**PLANNING AND COMMUNITY DEVELOPMENT**

**January 15, 2019**

Subject: VR-18-016 Neil Vacate Replat 1<sup>st</sup> Review

# WINETHIRTY PROPERTIES FILING NO. 1

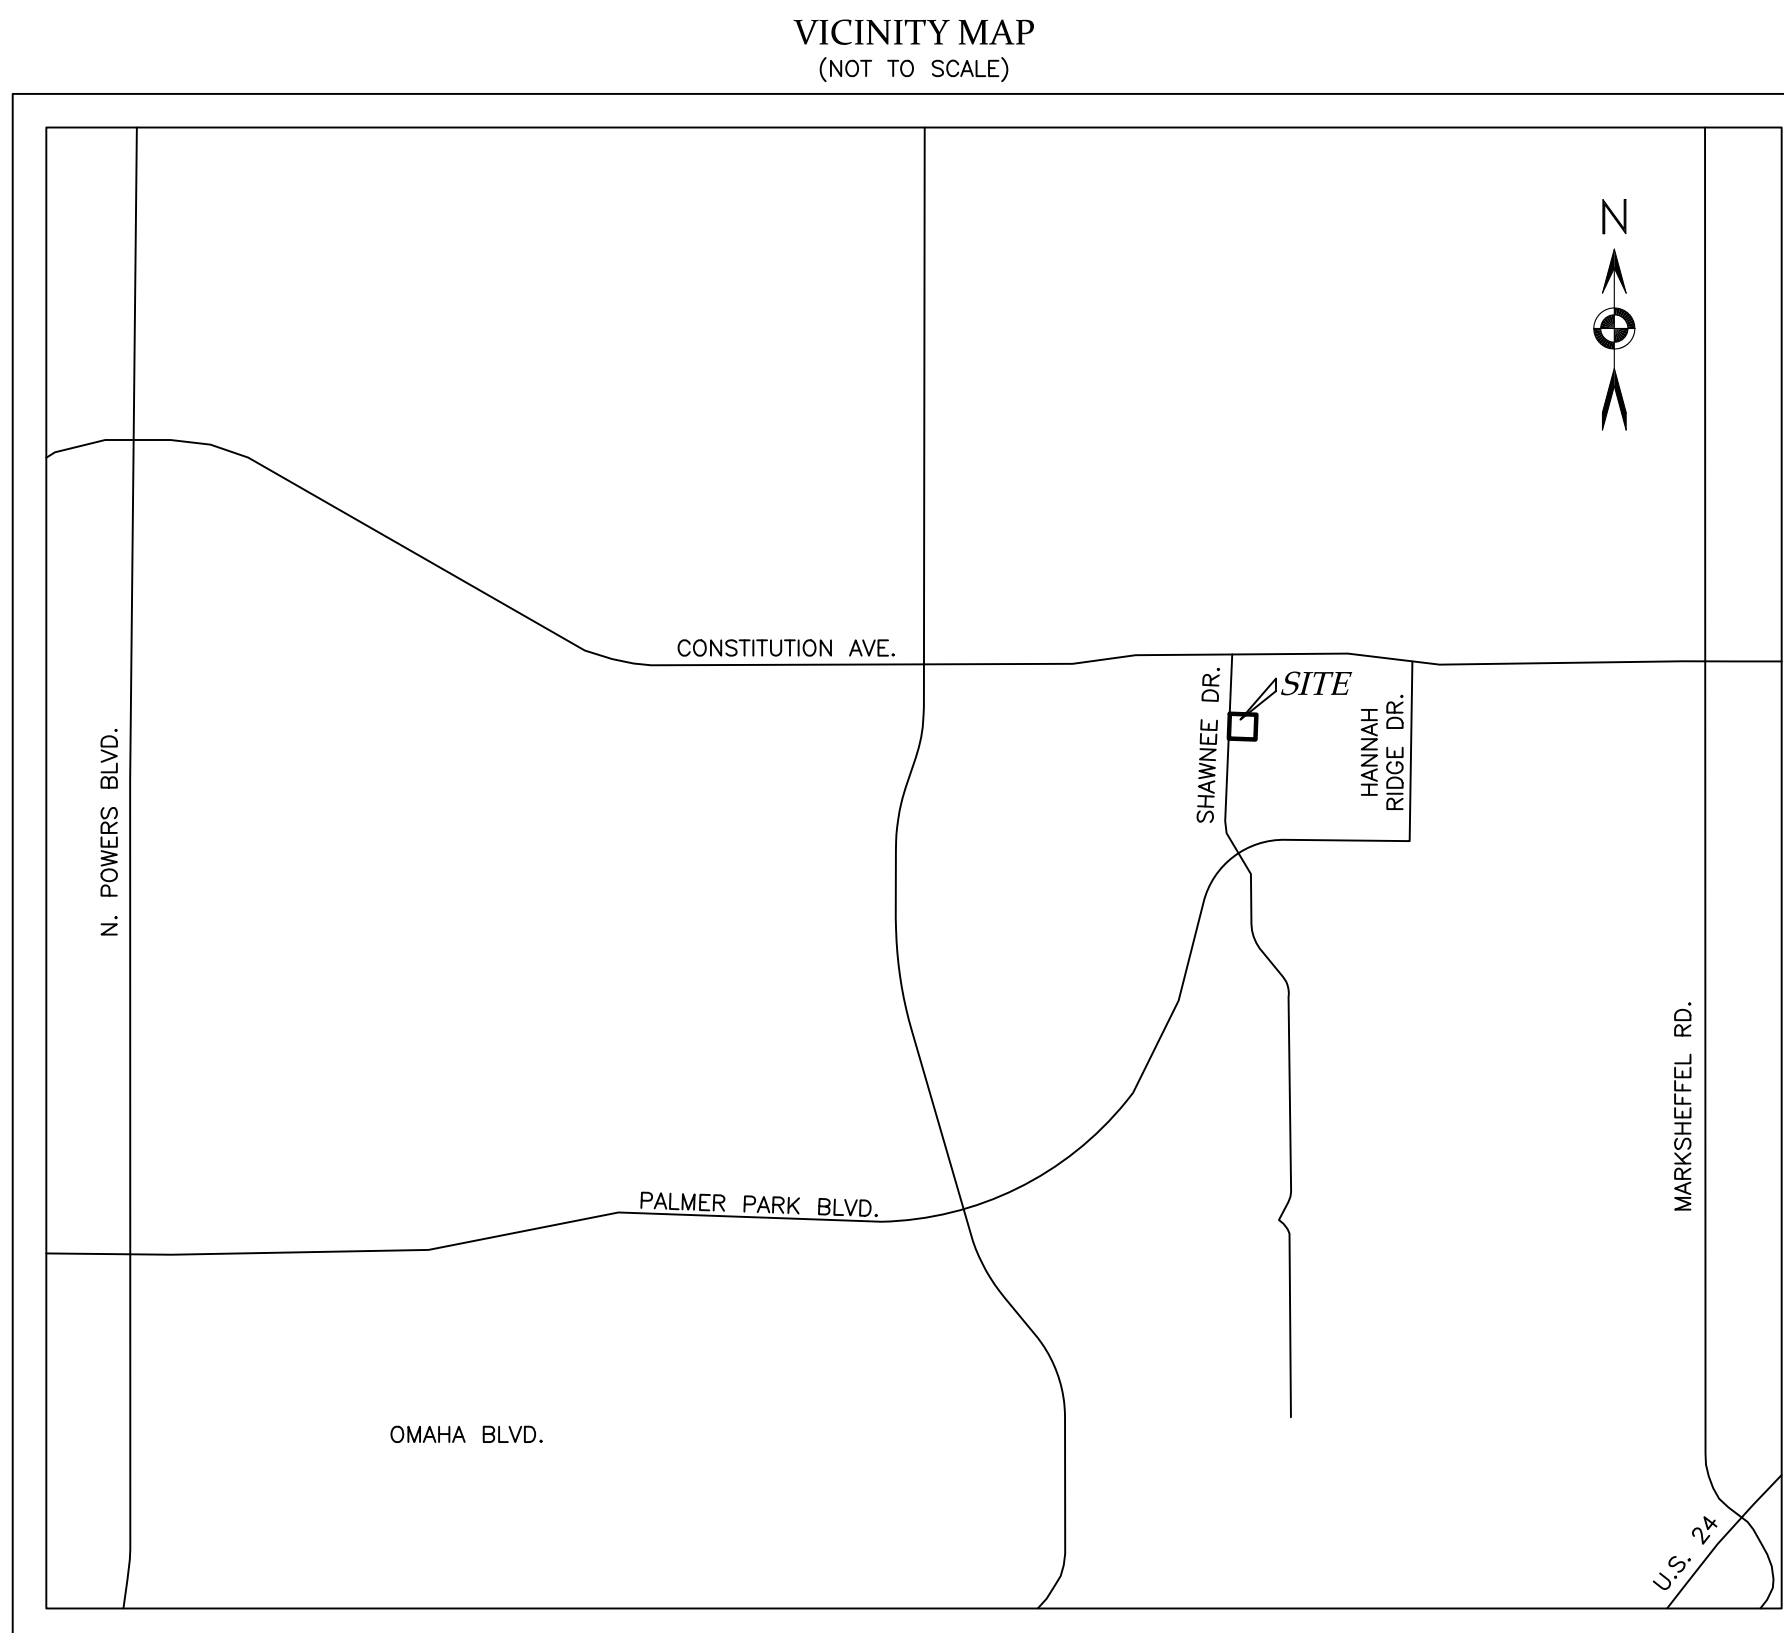
See redlines uploaded, be sure to address engineering and Pikes Peak Regional Building Comments listed below.

Project No.: 18125  
November 3, 2018  
Rev.: January 18, 2019  
Sheet 1 of 2

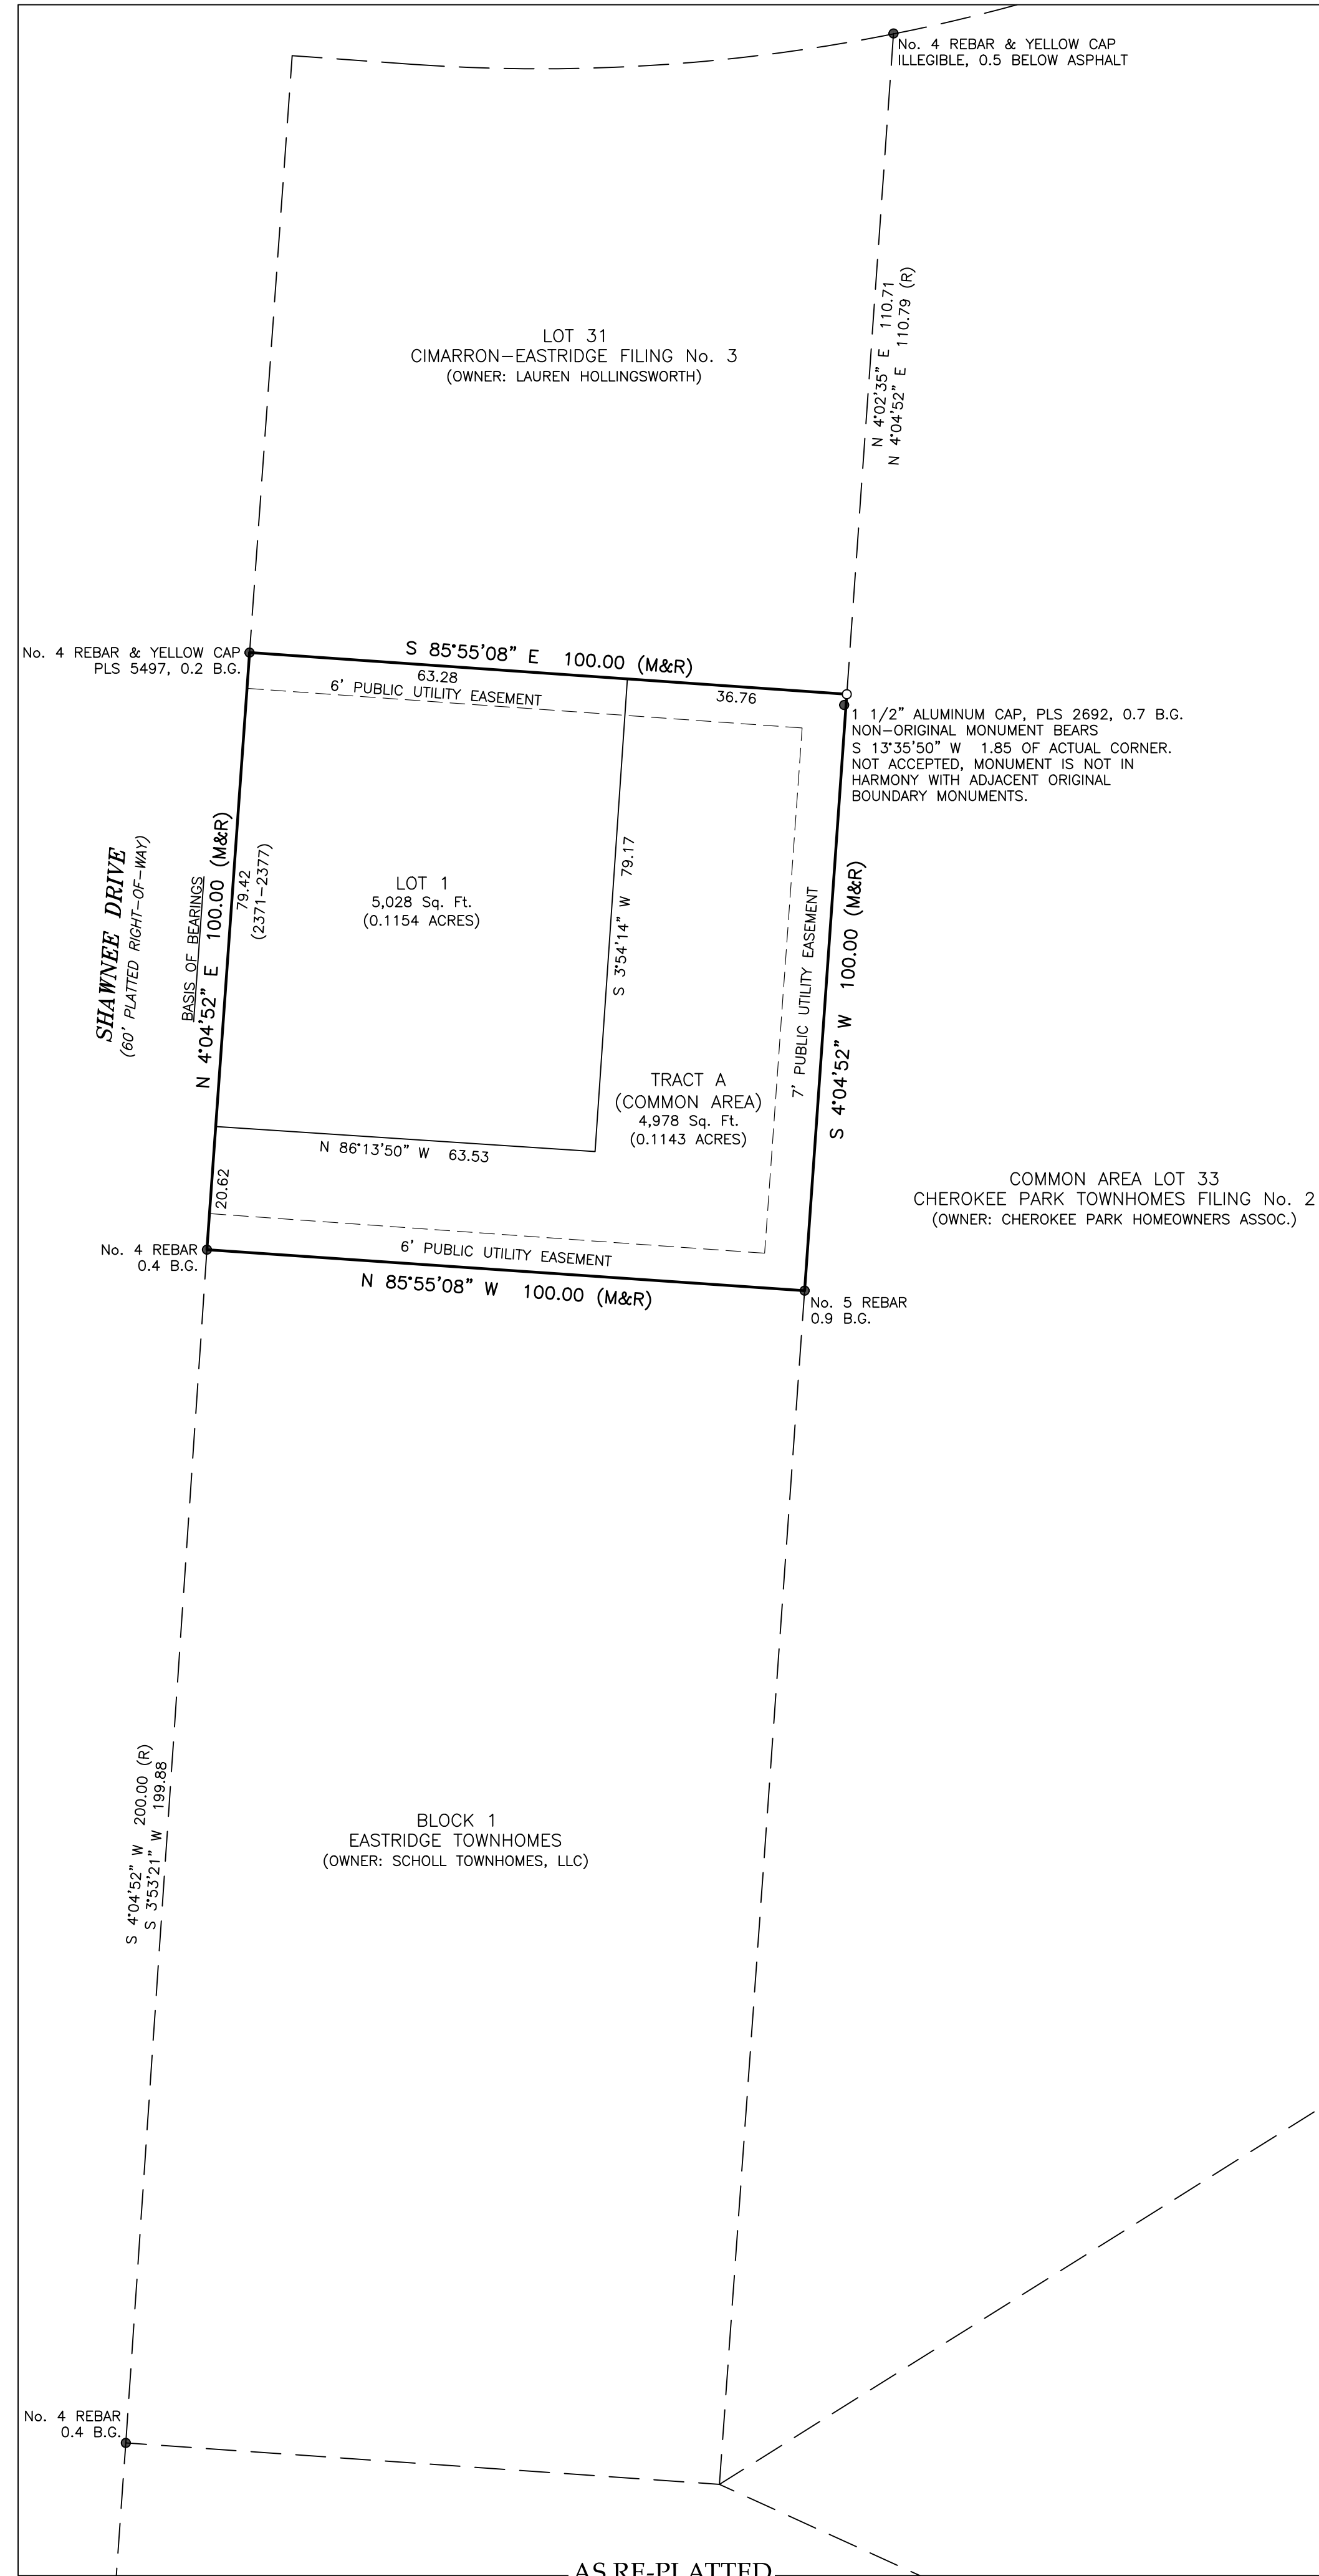
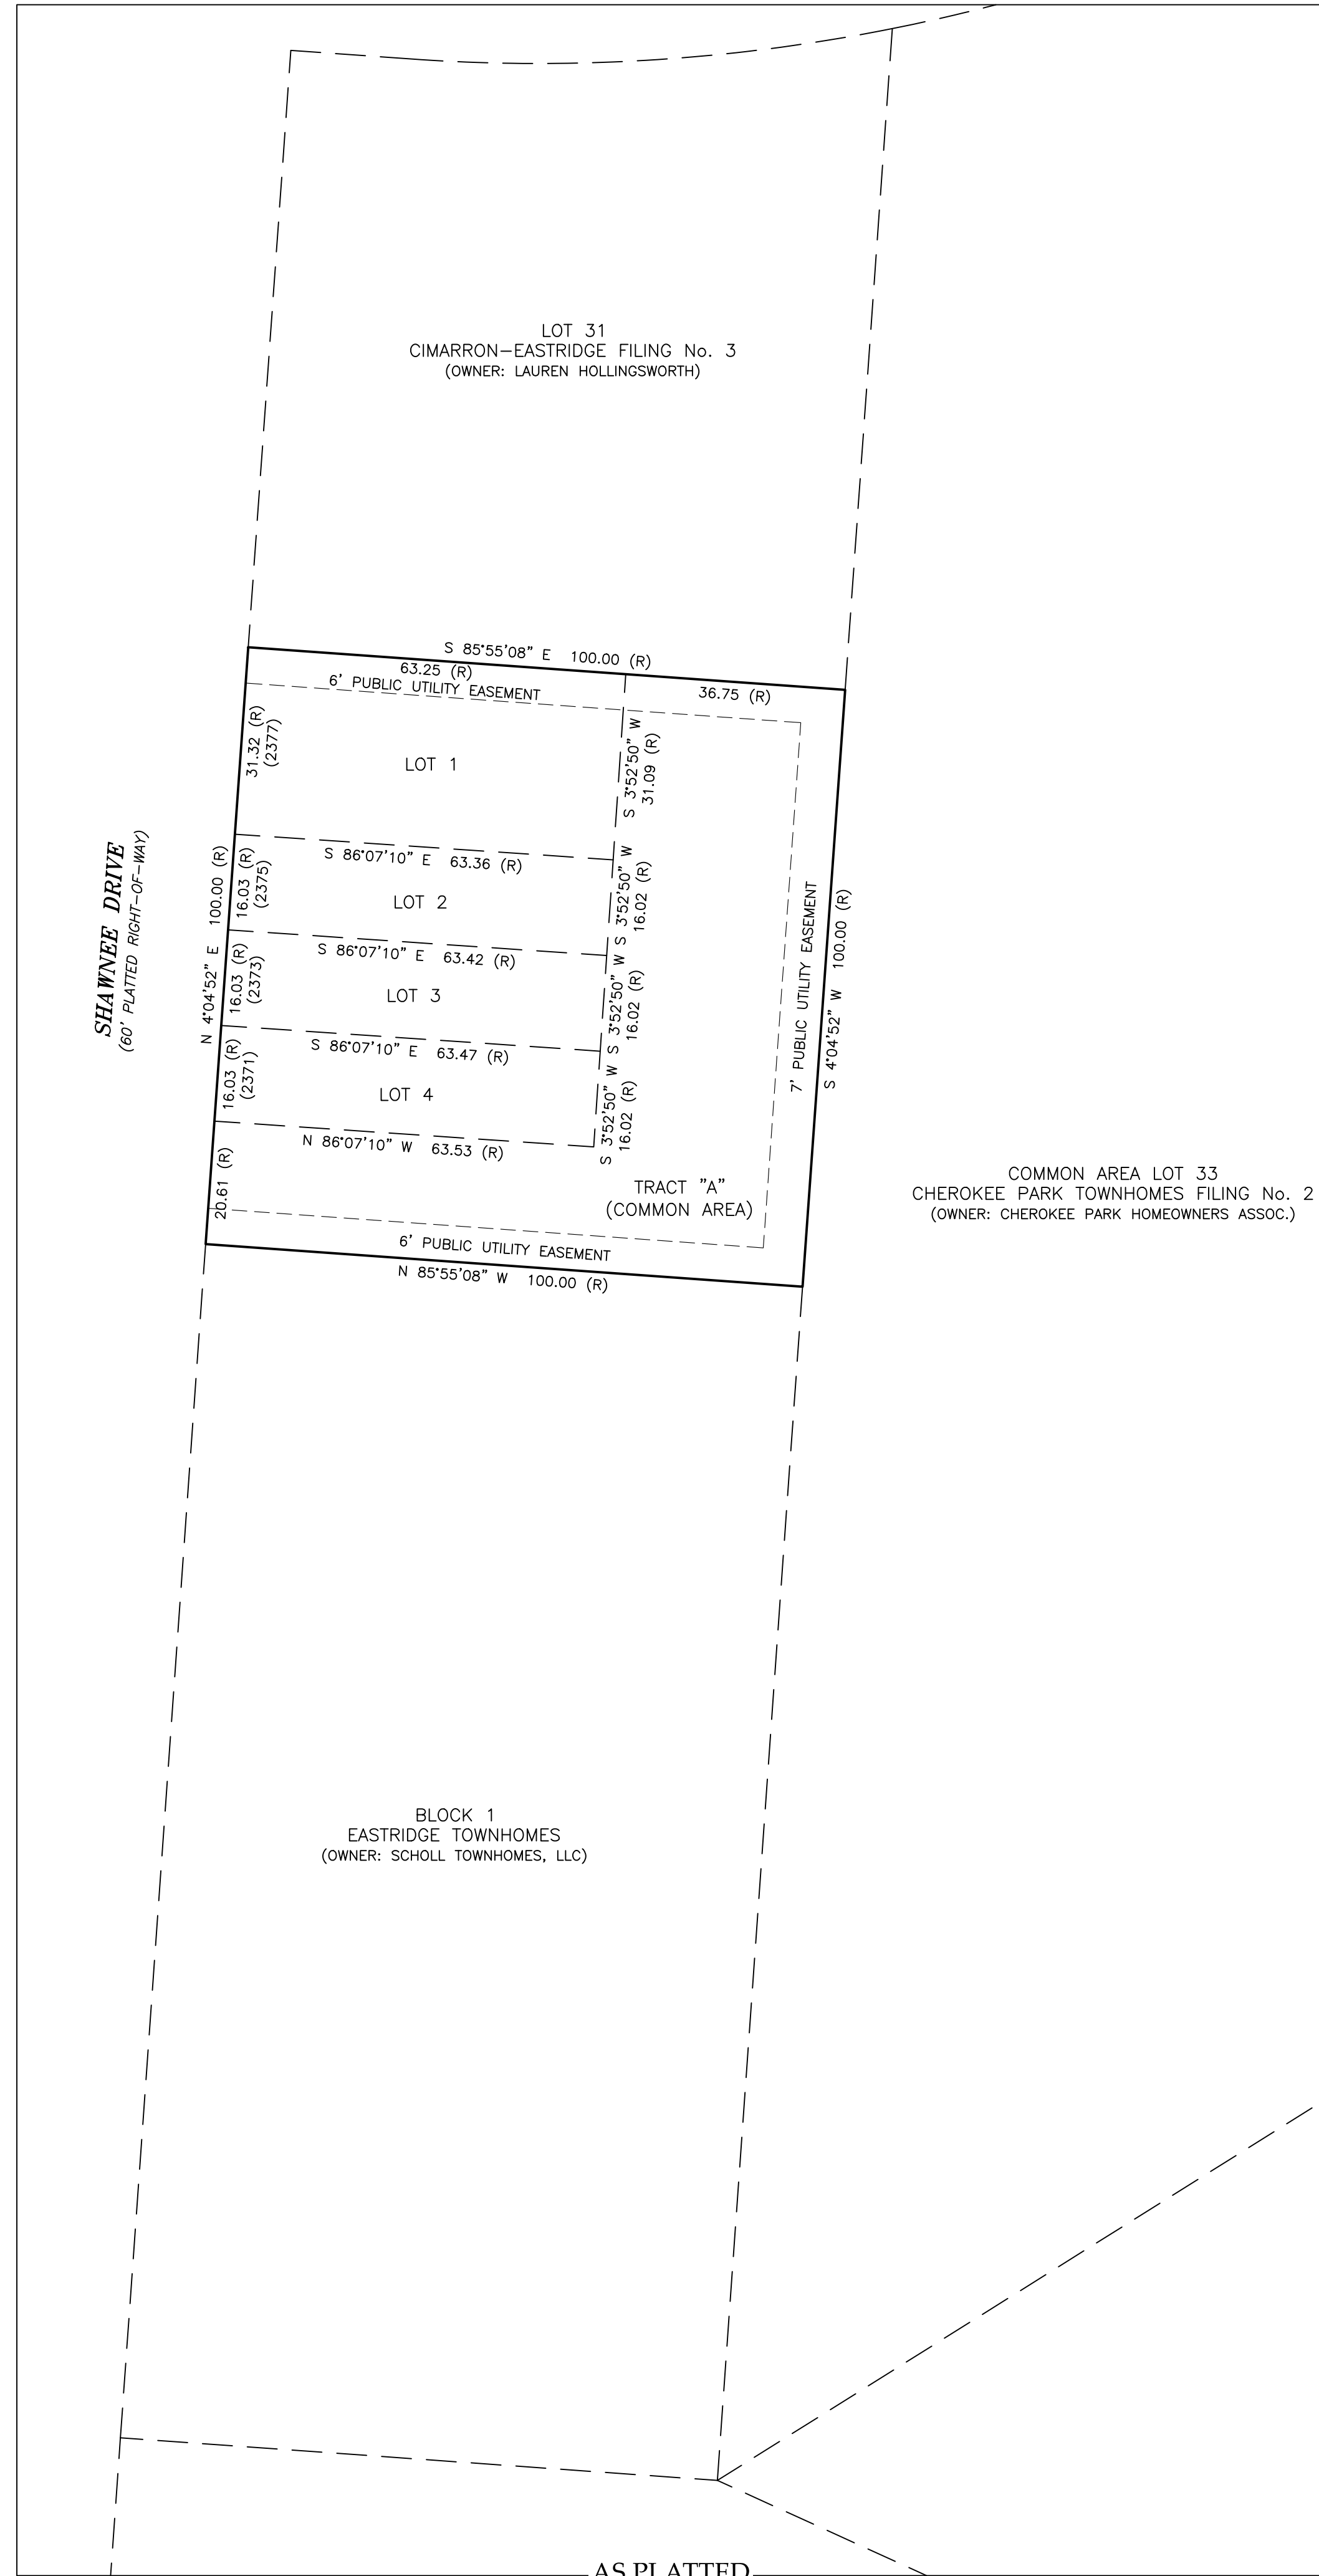
1. Address will be placed on the plat with a range of addressing. Address to be placed increasing from south to north. 2371-2377 Shawnee Drive.
2. There is no floodplain statement on the plat.
3. Standard final plat comments apply: ENUMERATIONS/FLOODPLAIN WILL REVIEW THE MYLAR PRIOR TO PLAT FOR ADDRESS PLACEMENT, ROAD NAMING, TITLE BLOCK, & FLOODPLAIN STATEMENT. \$10.00 PER LOT & TRACT FEE WILL BE DUE AT THE TIME OF THE REVIEW OF THE MYLAR. IF AN ADDRESS IS NOT NEEDED ON A TRACT THEN NO FEE APPLIES. CHECK SHOULD BE MADE OUT TO PIKES PEAK REGIONAL BUILDING DEPARTMENT. PAID DIRECTLY TO ENUMERATIONS DEPARTMENT. A COPY OF THE

Response from applicant: Above items have been added to the survey/plat.
